## Department of Primary Industries

**Wentworth Point mixed use development (SSD 6387)  
Response to exhibition of Environmental Impact Statement**

### **Wentworth Point mixed use development (SSD 6387) Response to exhibition of EIS Additional comments by NSW Office of Water**

CONCEPT SEDIMENT AND EROSION CONTROL PLAN

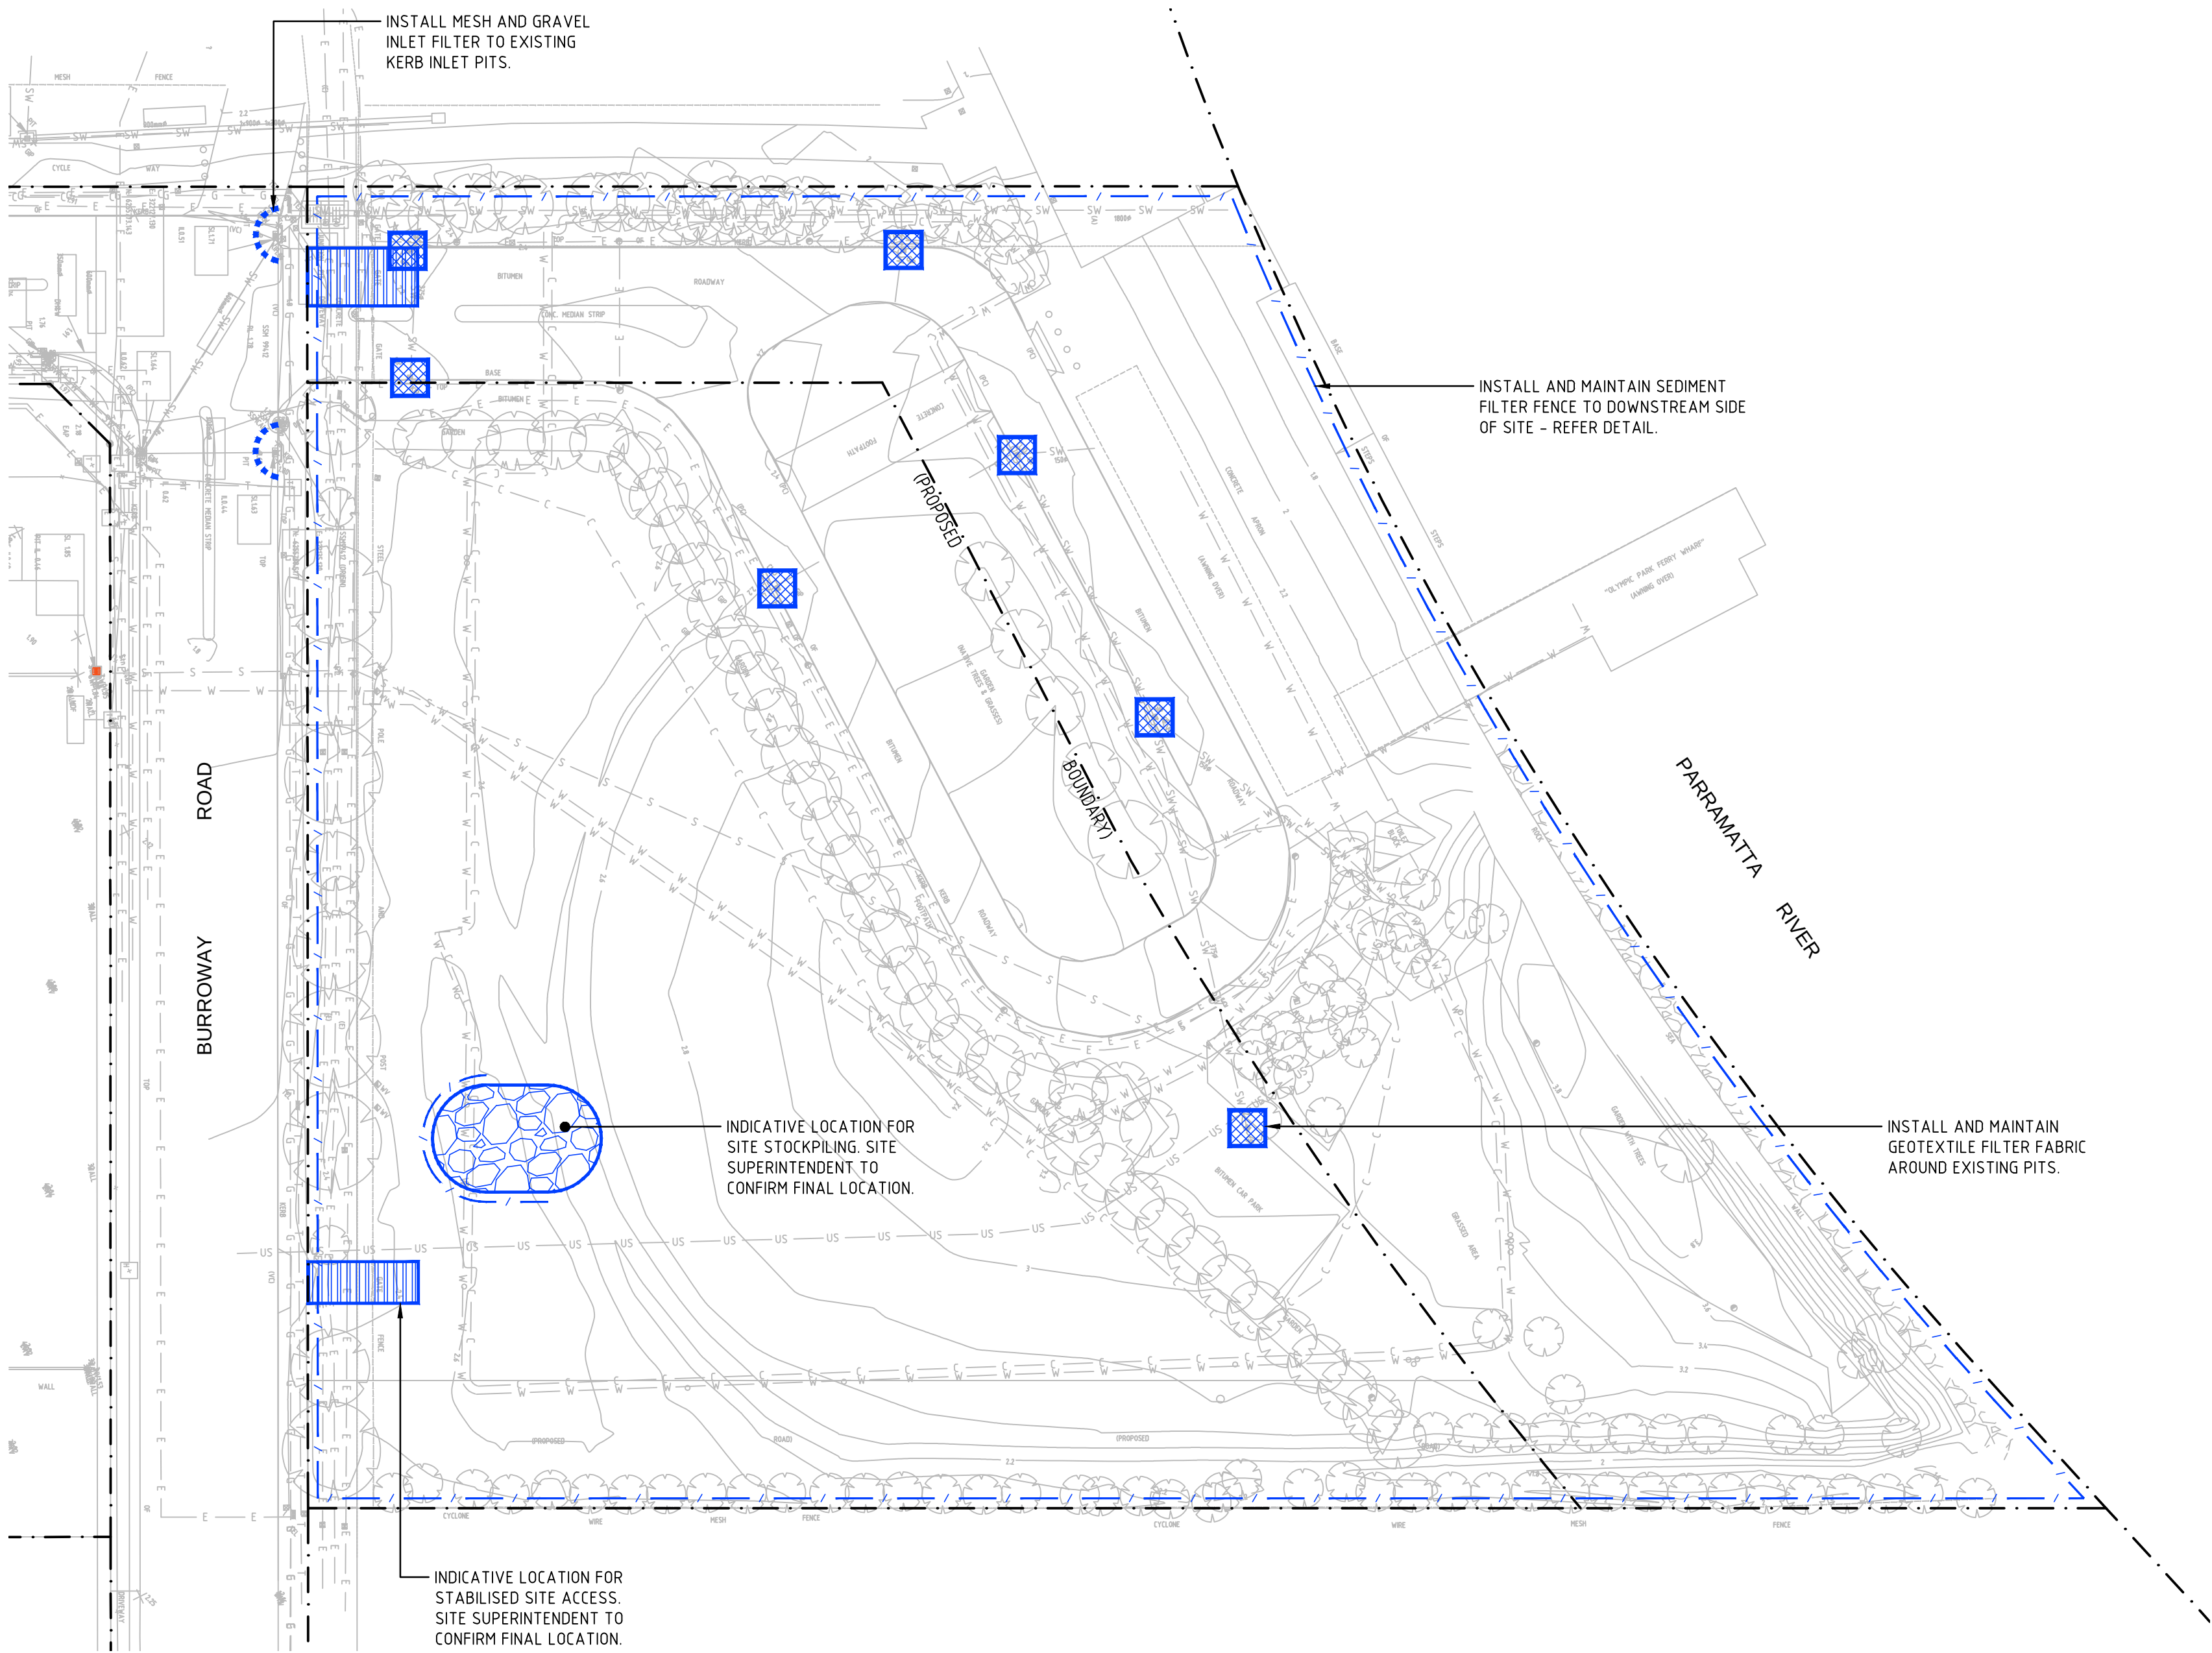
Any authorisation of the proposed temporary road within the riparian zone should ensure that this road is removed and the impacted area is revegetated as soon as possible after construction is completed. It is noted that there is no commitment within the Environmental Impact Statement to remove the temporary road and remediate this area following construction.

- a scaled plan which shows the location of the existing mature vegetation that is proposed to be retained and the riparian areas that are proposed for revegetation,
- encouraging landscaping on the development site to consist of native species from the relevant local vegetation community (particularly near the riparian corridor),
- removal and rehabilitation of temporary structures within the riparian corridor such as the temporary access road,
- maintenance requirements / weed control of the riparian corridor.
